CITY OF ALBUQUERQUE
MUNICIPAL DEVELOPMENT DEPARTMENT
ENGINEERING DIVISION/DESIGN HYDROLOGY SECTION

CONFERENCE RECAP

DRAINAGE FILE/ZONE ATLAS PAGE NO.: K15 DATE: 4-17-89
PLANNING DIVISION NOS: EPC: _____ DRB: _____
SUBJECT: Nursing Home
STREET ADDRESS (IF KNOWN): 236 High St.
SUBDIVISION NAME: High & Grand

GRADING AND
DRAINAGE PLAN

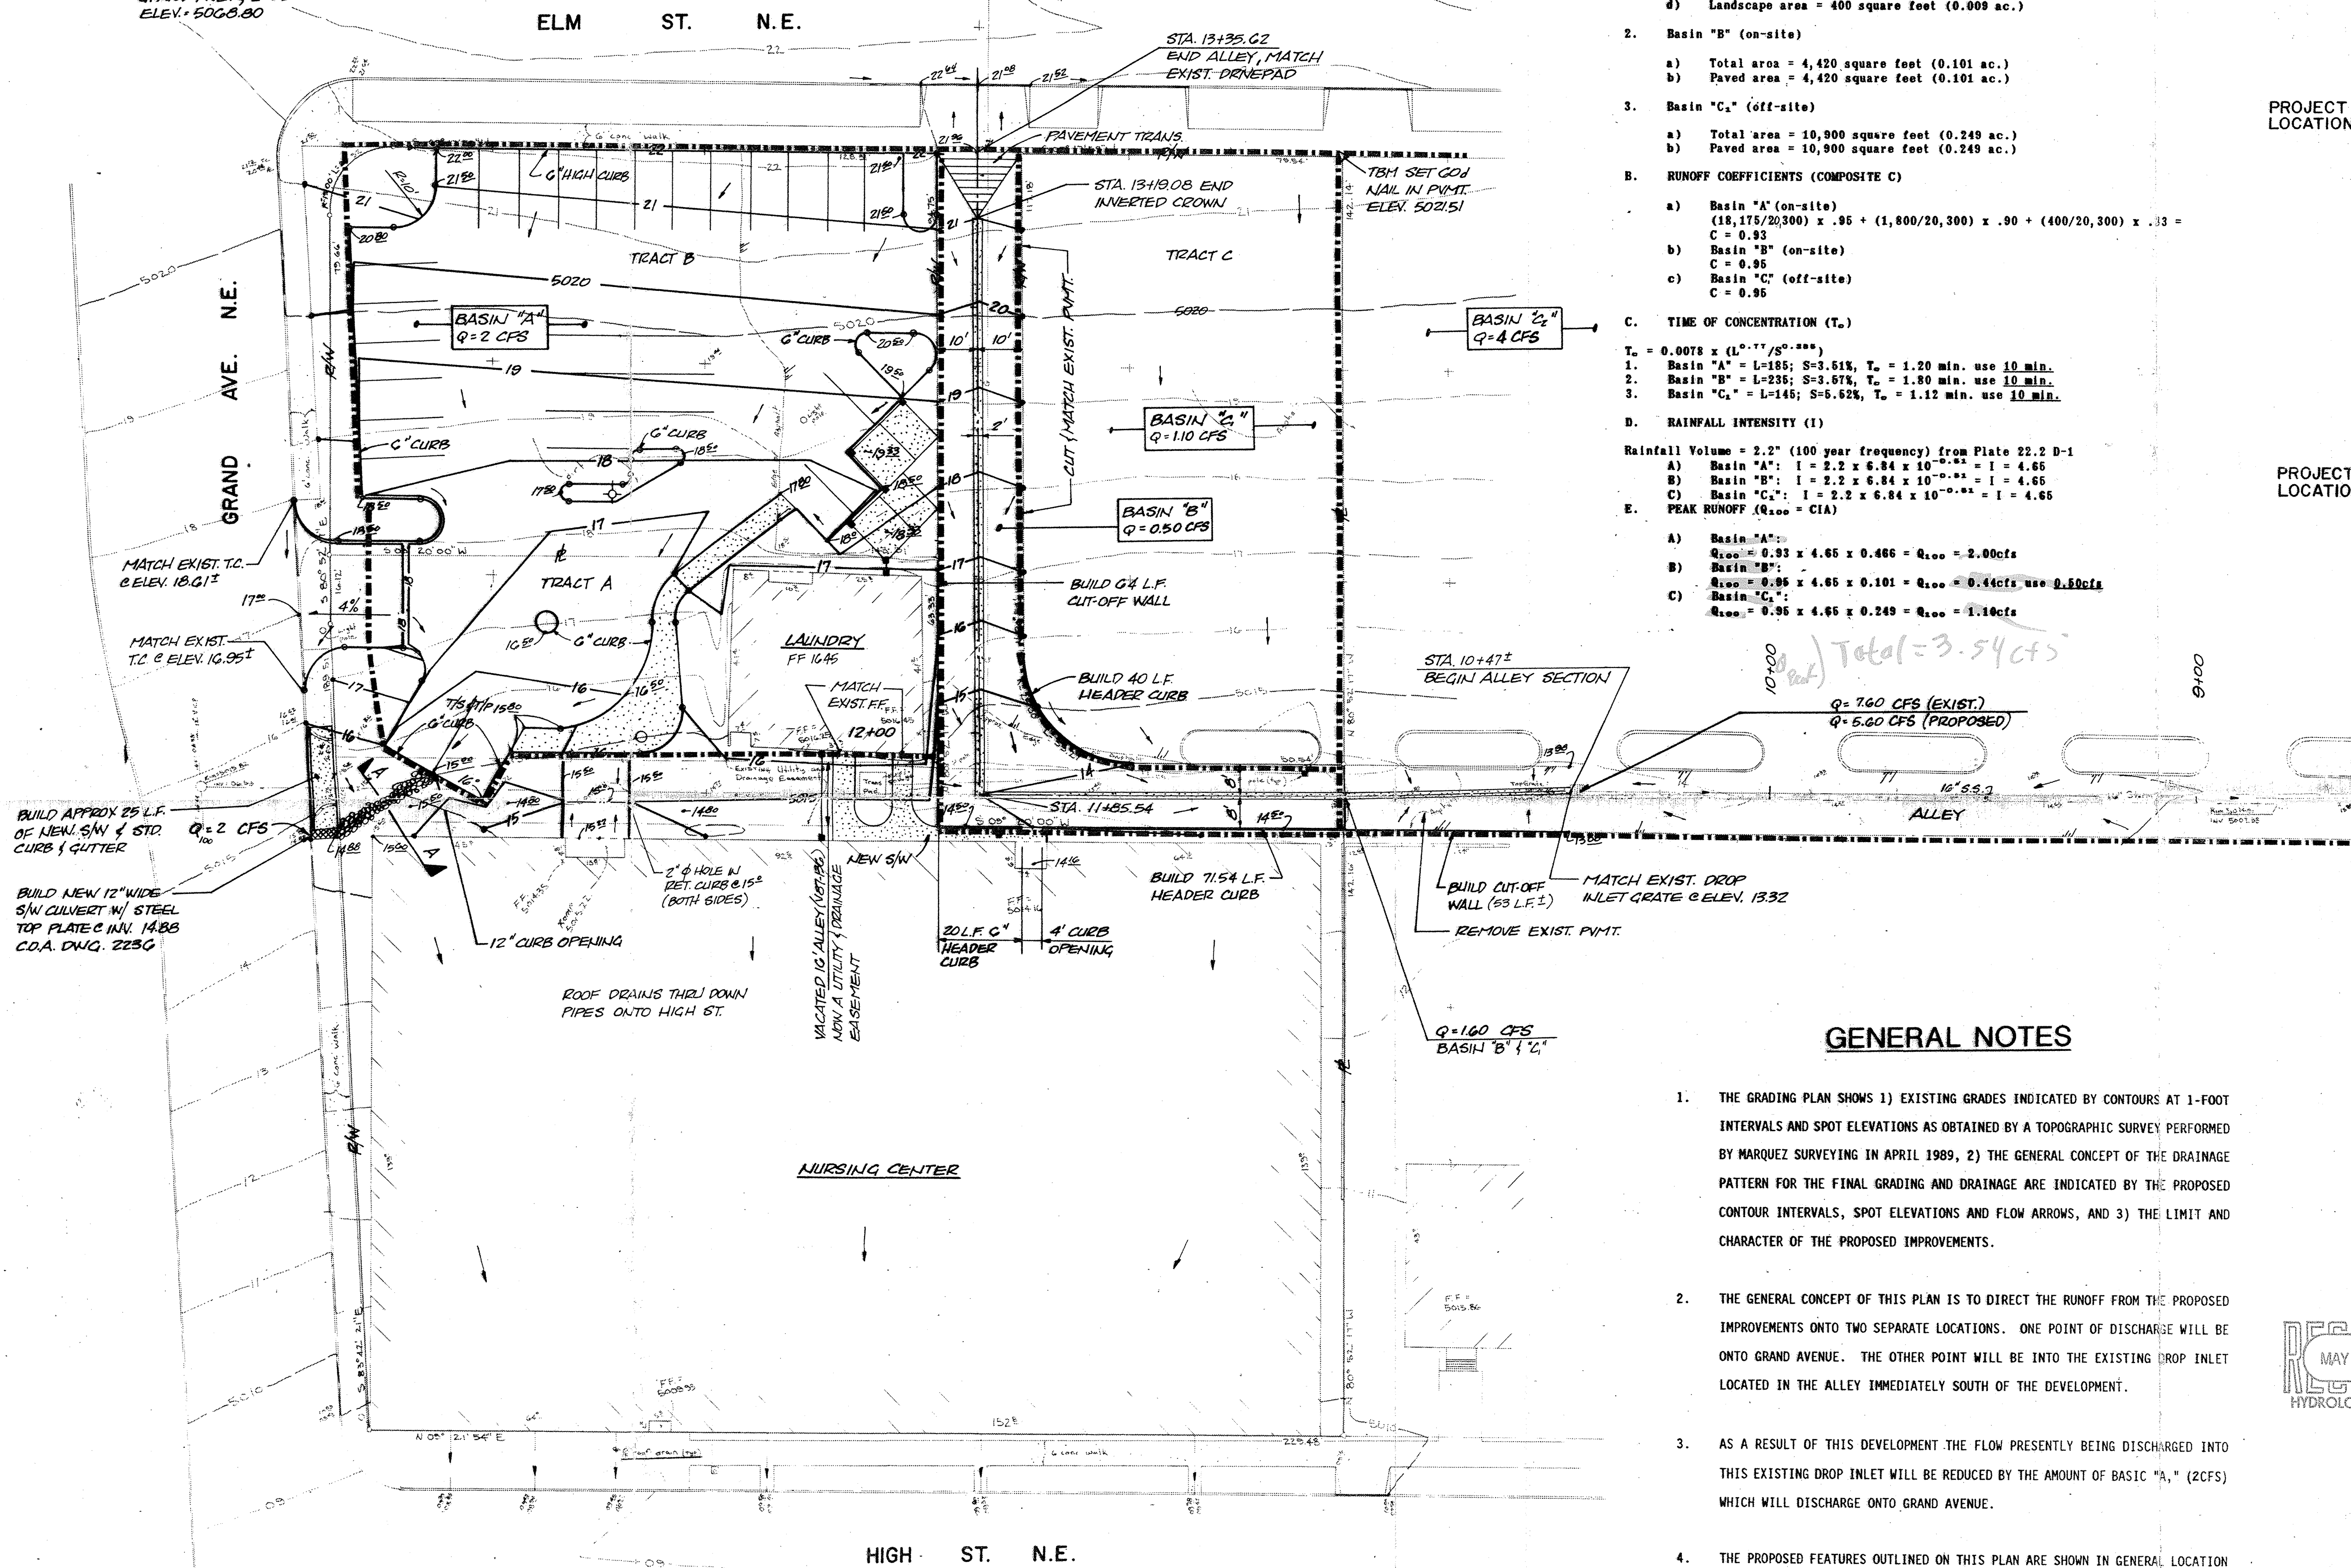
- ① Drawn plan per DPM
- ② Need ally grades from Elm St to Copper Ave.
- ③ Need to review DRB 27-772 for ally requirements
- ④ Need City standard ally section from Elm St to south property line. DRC will determine ally section south of property to Cooper Ave. It ally does not have
- ⑤ Need to show capacity of ally and storm drain systems.
- ⑥ Free discharge allowed to Grand. Free discharge from ally to Cooper.
- ⑦ Storm drain ^{improvements} requires DRC approval.
- ⑧ Parking permit will not be released until ally has been reviewed by DRC.
